Our Ref: BR/62/13/A
Your Ref:

Town & Country Planning (Control of Advertisement) (England) Regulations 2007 (as amended)
Application for Consent to Display an Advertisement(s)

Development 2 No back illuminated fascia signs and 1 No internally illuminated projecting sign
Location 43-45 Queensway Bognor Regis

proposed
projecting sign
600mm high x
750mm wide

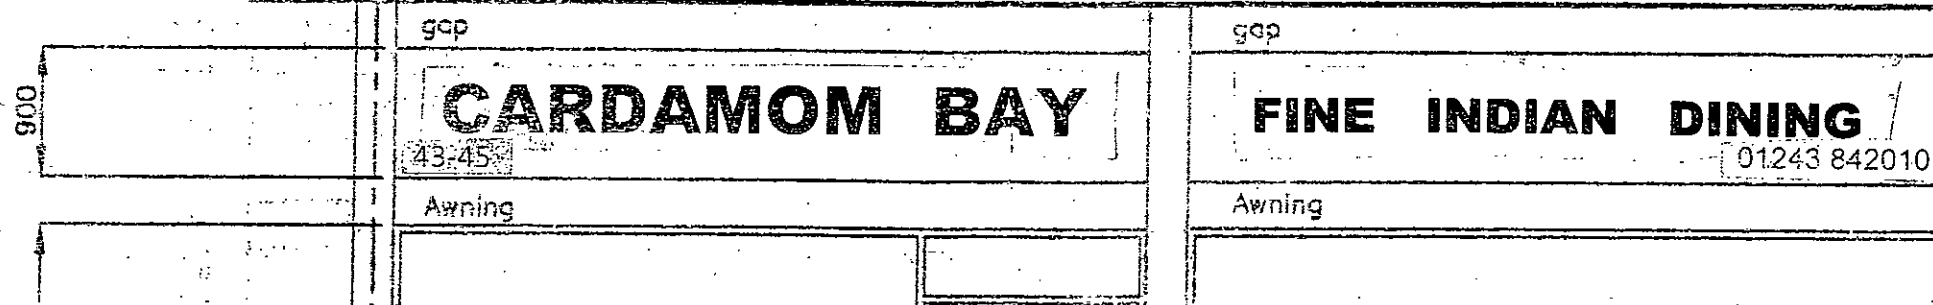
Please show the details of the projecting sign.

BLOCK PLAN - REV A 19.03.13

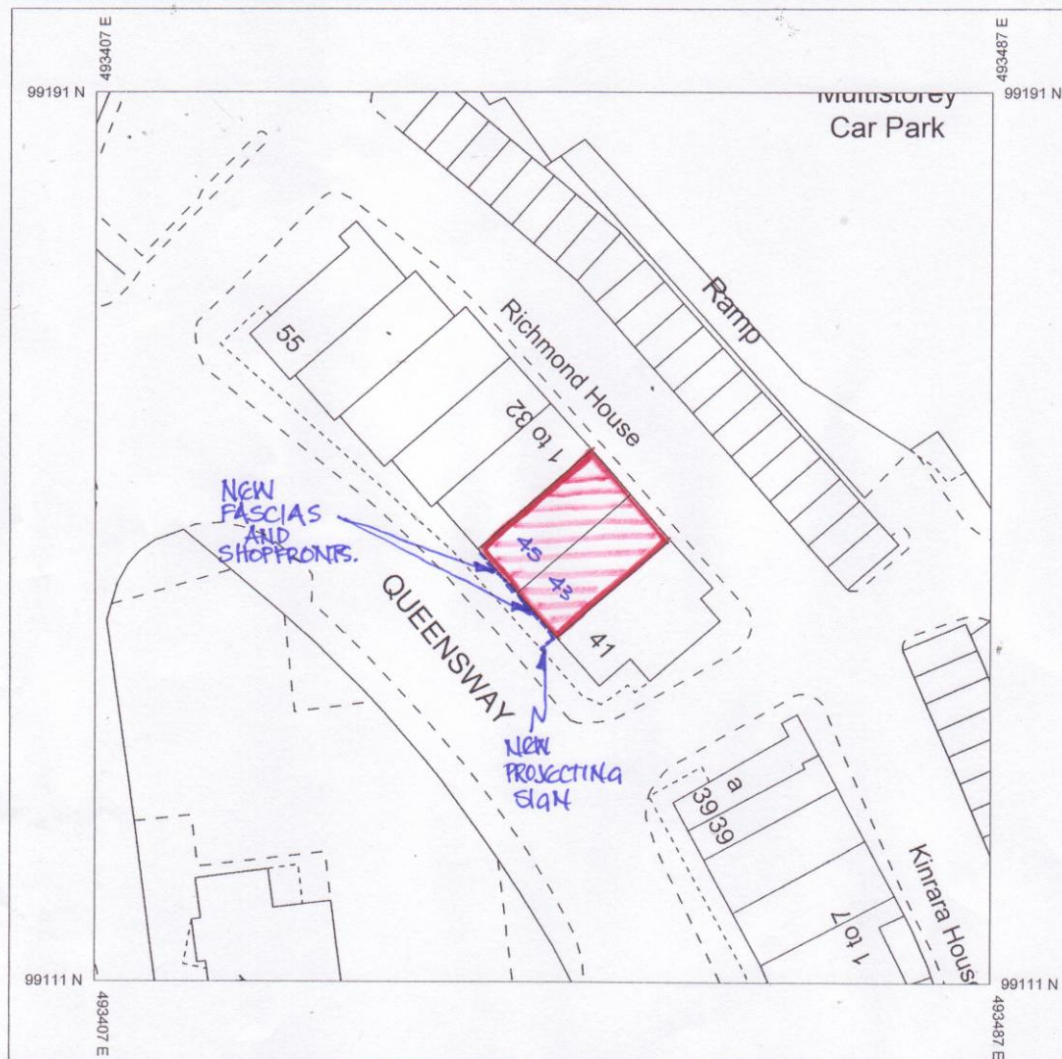
Please highlight on the block plan where the proposed advertisements will be located.
